| Application number: 2025/90099   |                                                                                  |
| What is the application for?:    | Erection of single and two storey extensions to the side, front and rear and for |
| Address of the site or building: | 7, Bradley Grange Gardens, Bradley, Huddersfield, HD2 1QX                        |

| Type of comment: An objection

Title: PROPOSED REVISED LAYOUT.

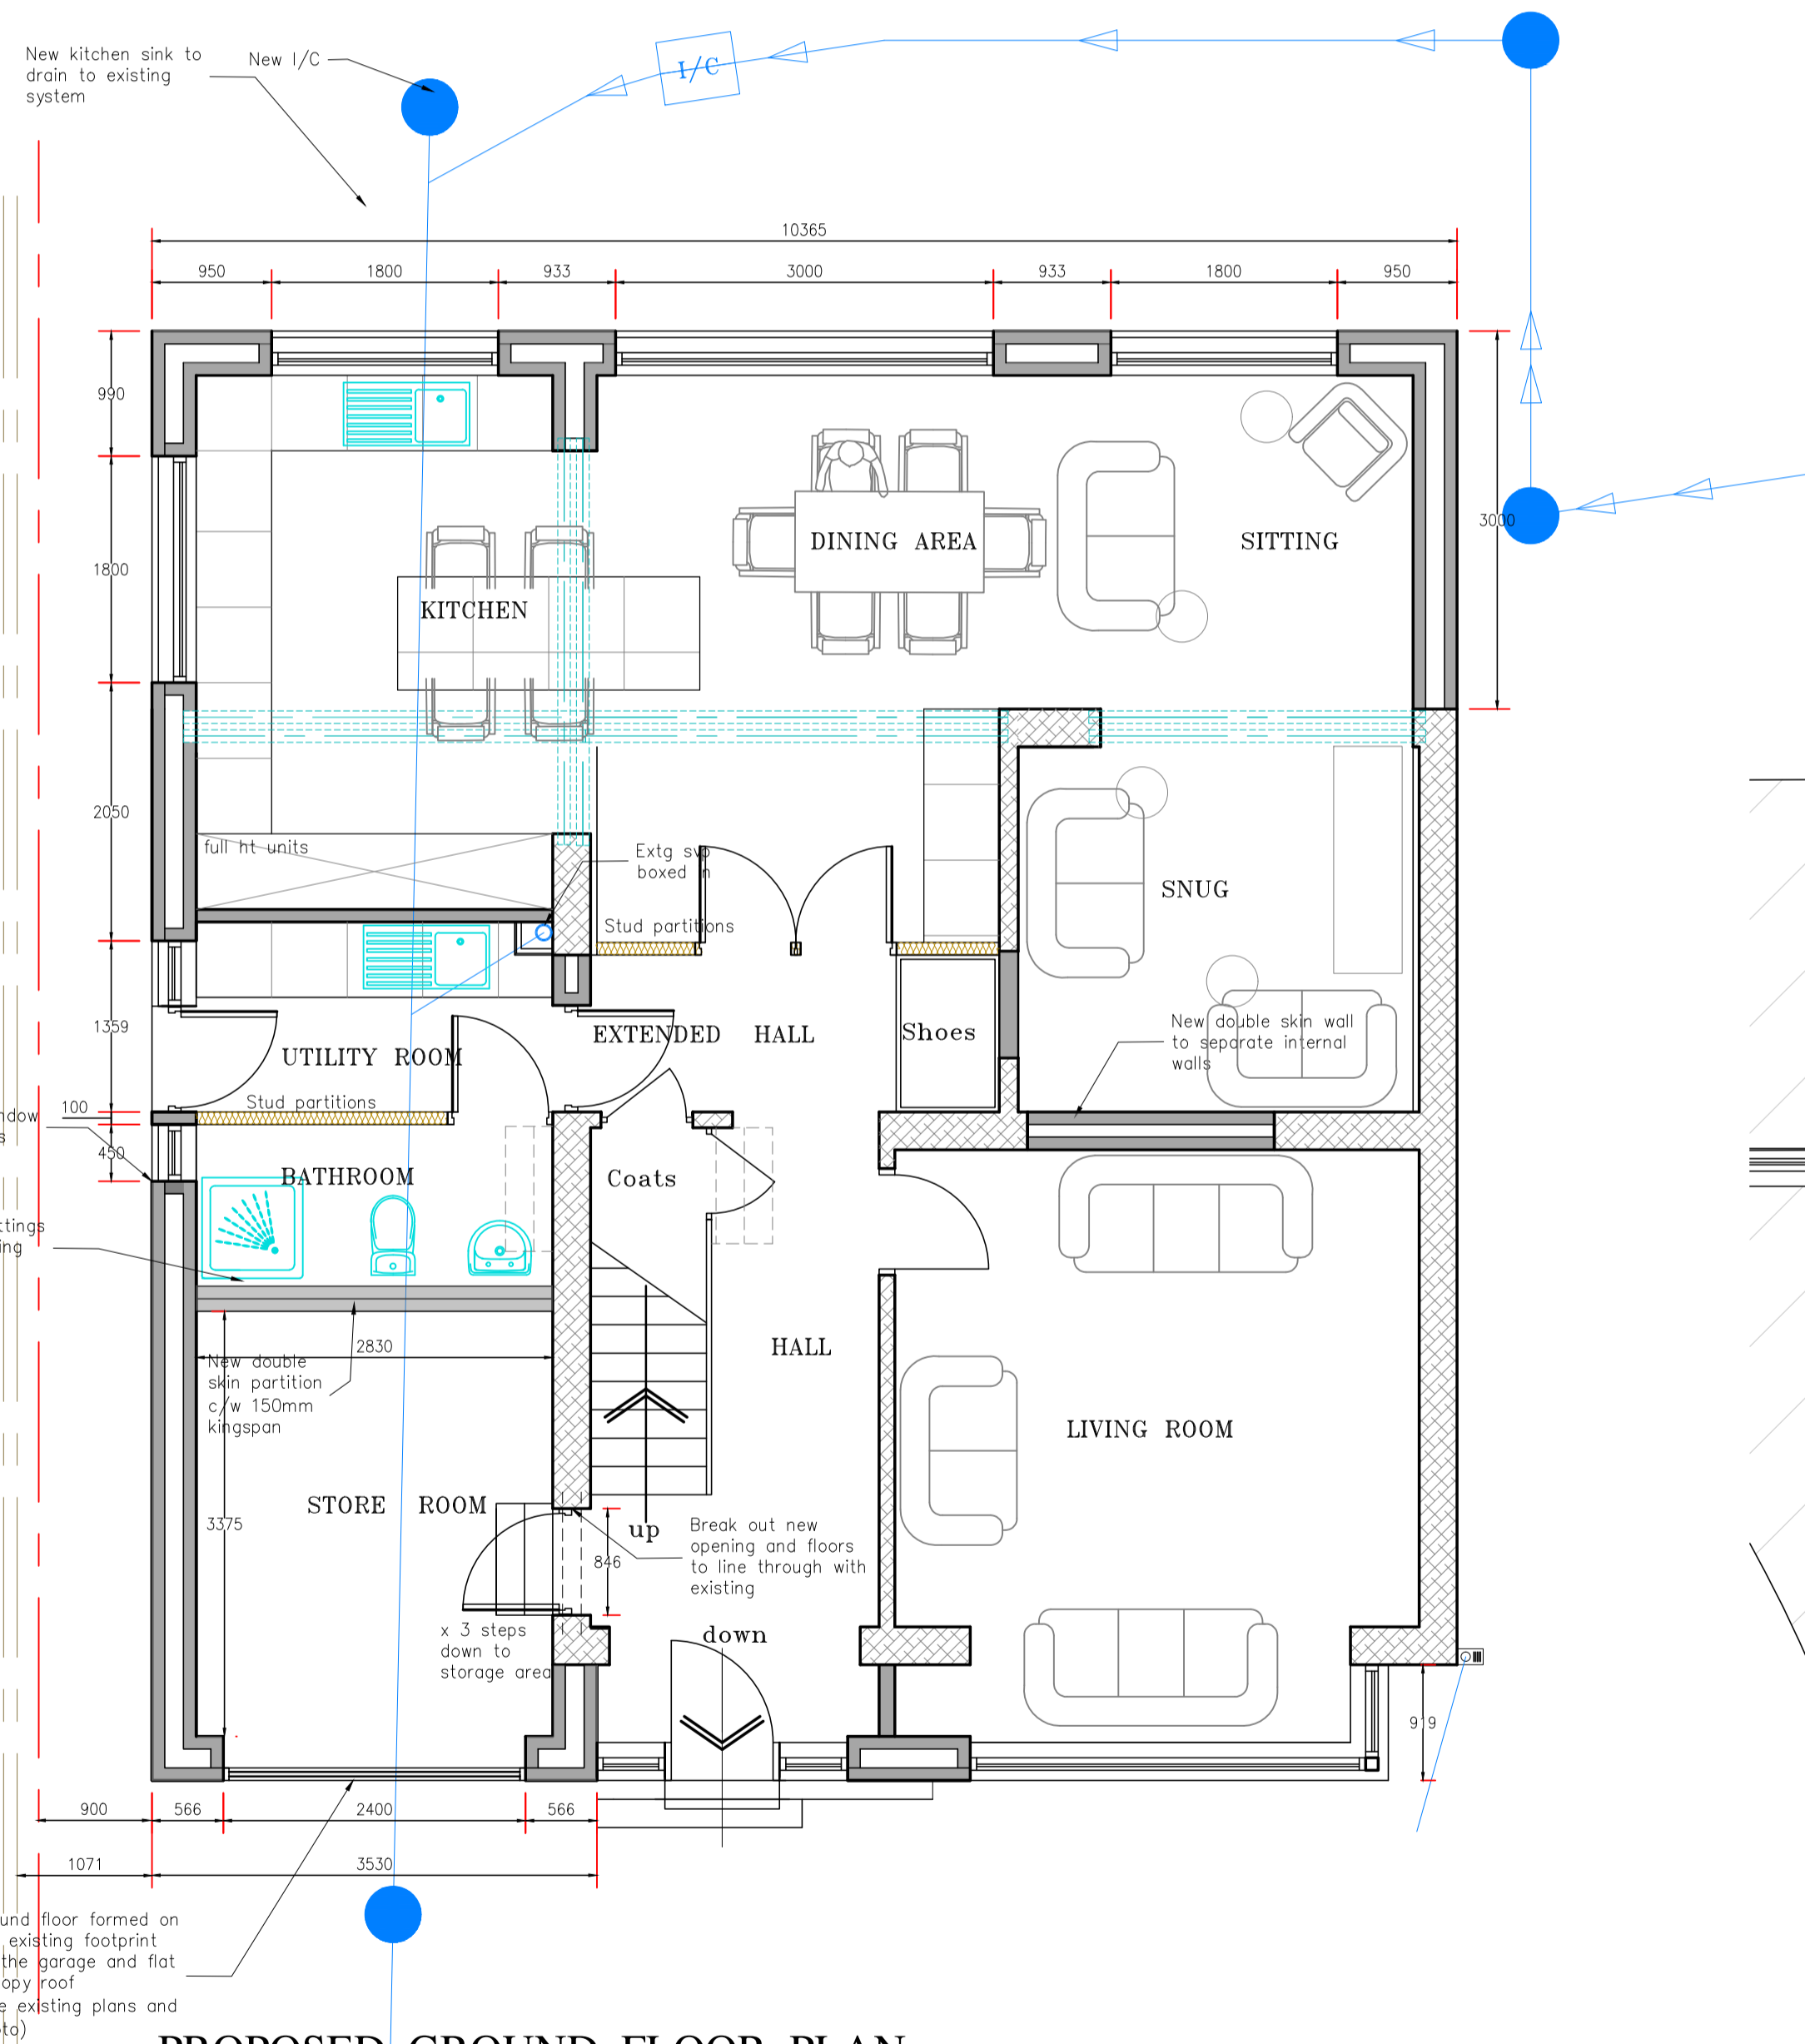
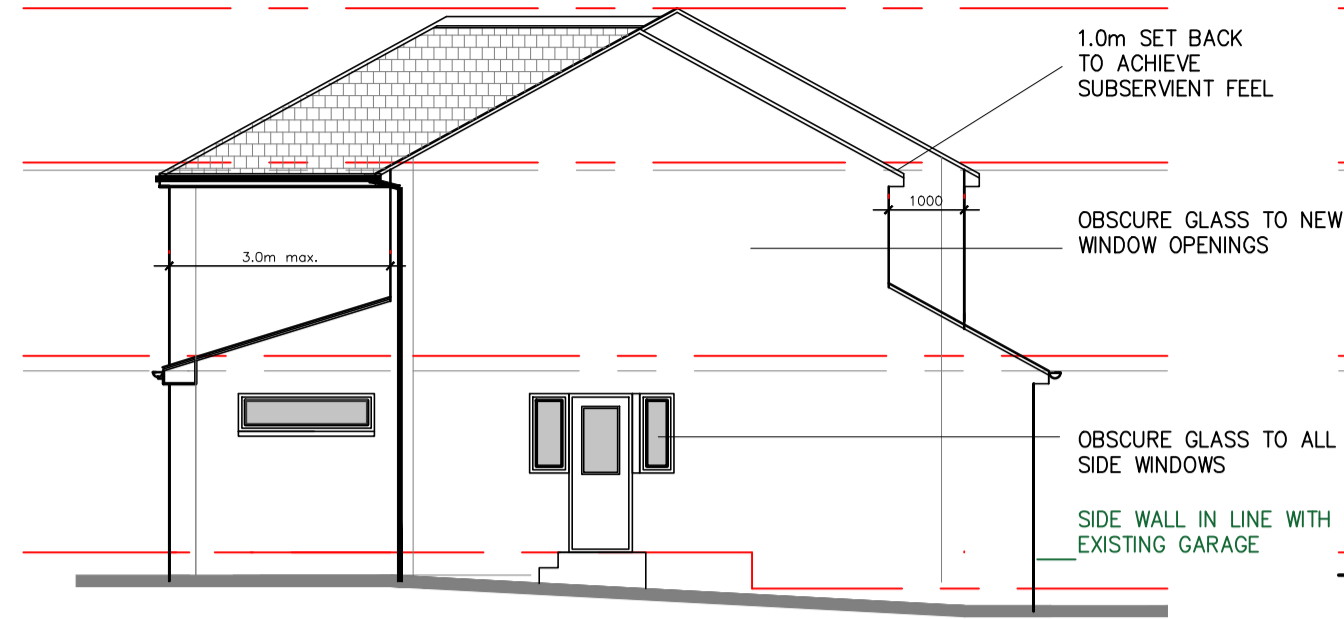
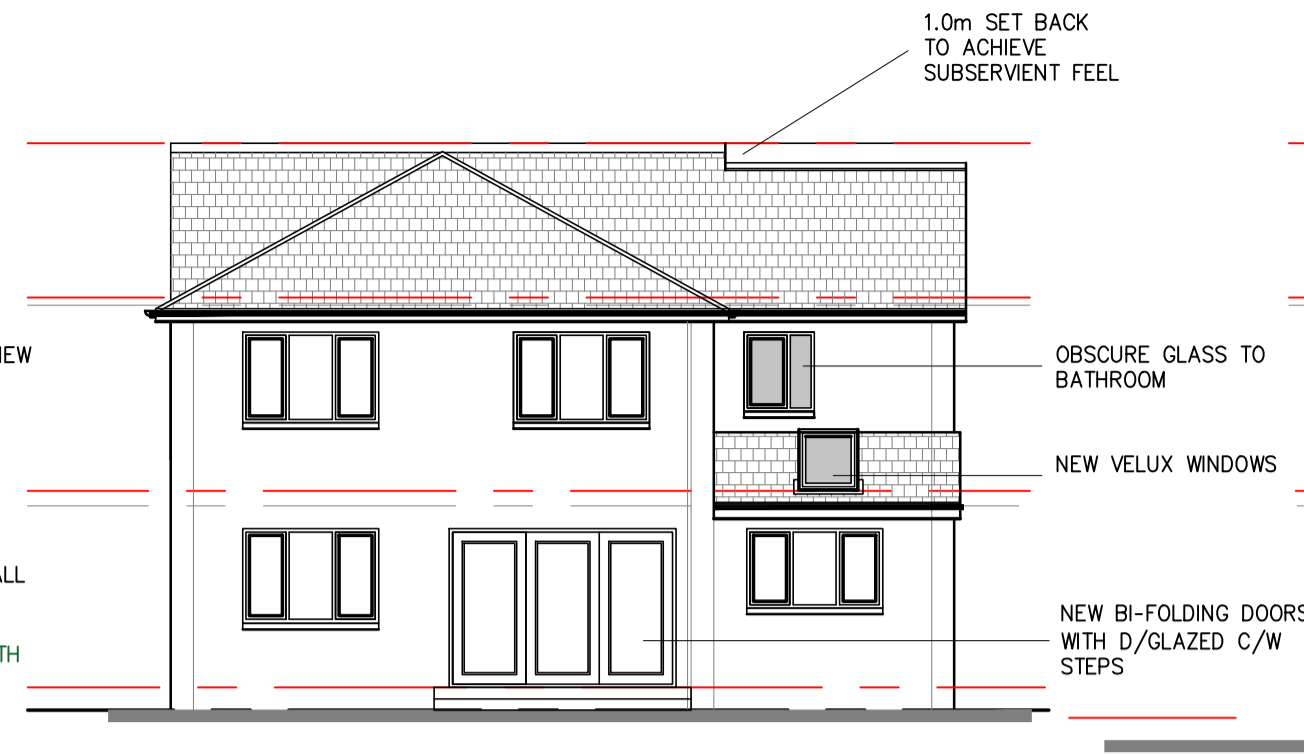
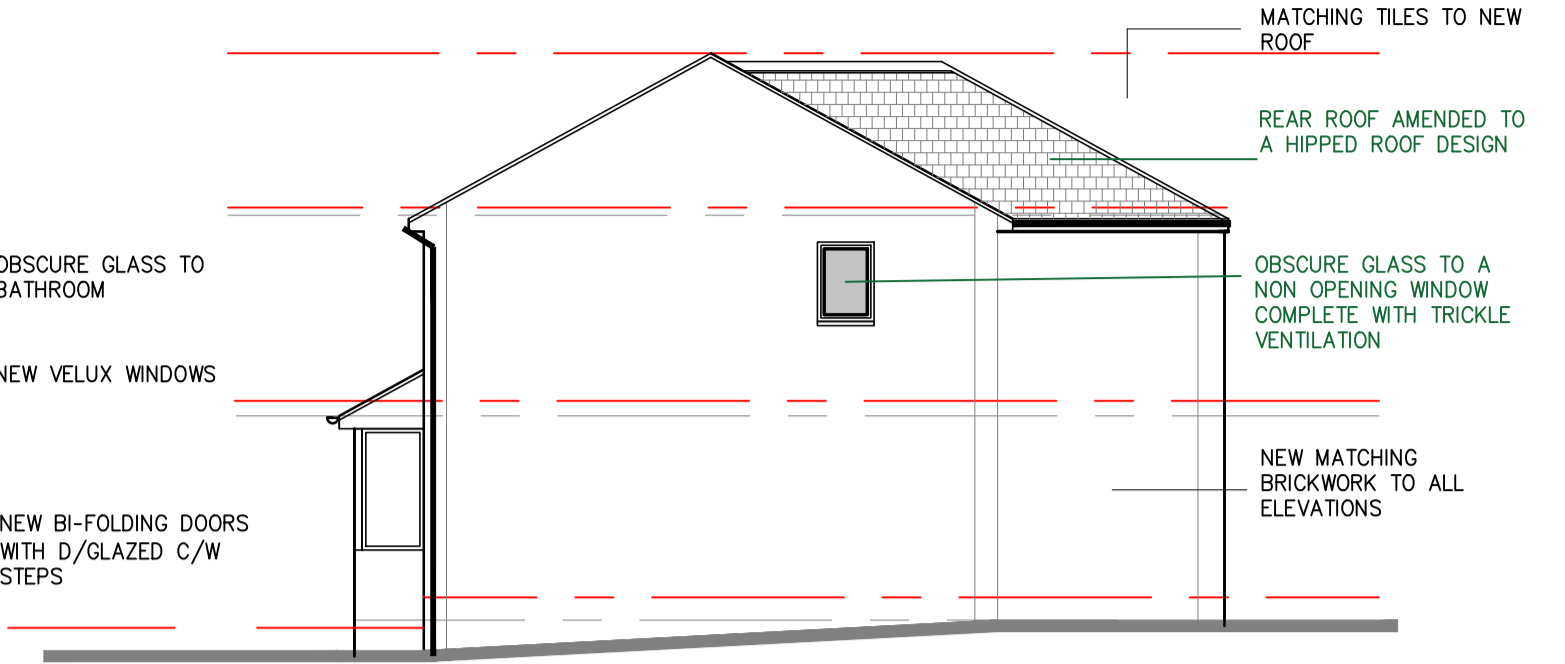
| <p>We wish to object once again to number 7's planning application for the below reasons:</p> <ul style="list-style-type: none"><li>• Too large for the plot to be in keeping with the streets character.</li><li>• Reduction of green space around the property, impacting on local wildlife and overall appearance.</li><li>• There are large conifer trees at the back of the property which are within falling distance of the new proposed plans. These are not listed on the planning forms. Are these to remain? If removed, they will remove any privacy the rear property have from such a large extension. Also impacting on local wildlife.</li><li>• The rear two story extension would significantly impact on the already limited natural light entering number 9 Bradley Grange Gardens Side bedroom (Dorma window to the left of number 9) making the room cold and dark. Increasing energy bills to heat and light the room throughout the day.</li><li>• Upstairs bathroom proposal continues to look directly into my young daughters bedroom which has an open plan shower room. Highly inappropriate to be overlooked, regardless of new plans to have concealed glass. This becomes obsolete once the window is opened.</li><li>• Number 9's window does not have privacy glass as there has never been a need to fit privacy glass due to not being overlooked. Plus, the fact privacy glass again would darken the room and a cost we would have to incur.</li><li>• Concerns regarding increased noise affecting number 9's side bedroom, with a window direct opposite young daughters bedroom.</li><li>• New proposed balcony is not in keeping with the area. Will it be a functional balcony? Or decorative?</li><li>• The plans show the redirection of the underground soil pipe. We have lived here since 2020 ( and my parents 30+ years prior) and there has always been issues with these pipes getting blocked. The new proposal indicates bends in the flow of the pipe, which will increase further risks of problems with the drainage systems.</li></ul> |    |

- The new plans do not appear to have changed, other than the front left side extension being reduced slightly. No consideration has been taken by the planners to review any previous comments made by neighbours who this would affect.
- Number 5 and 9 Bradley Grange Gardens gardens would continue to be overlooked, overshadowed and spoiled by such a large and protruding extension.
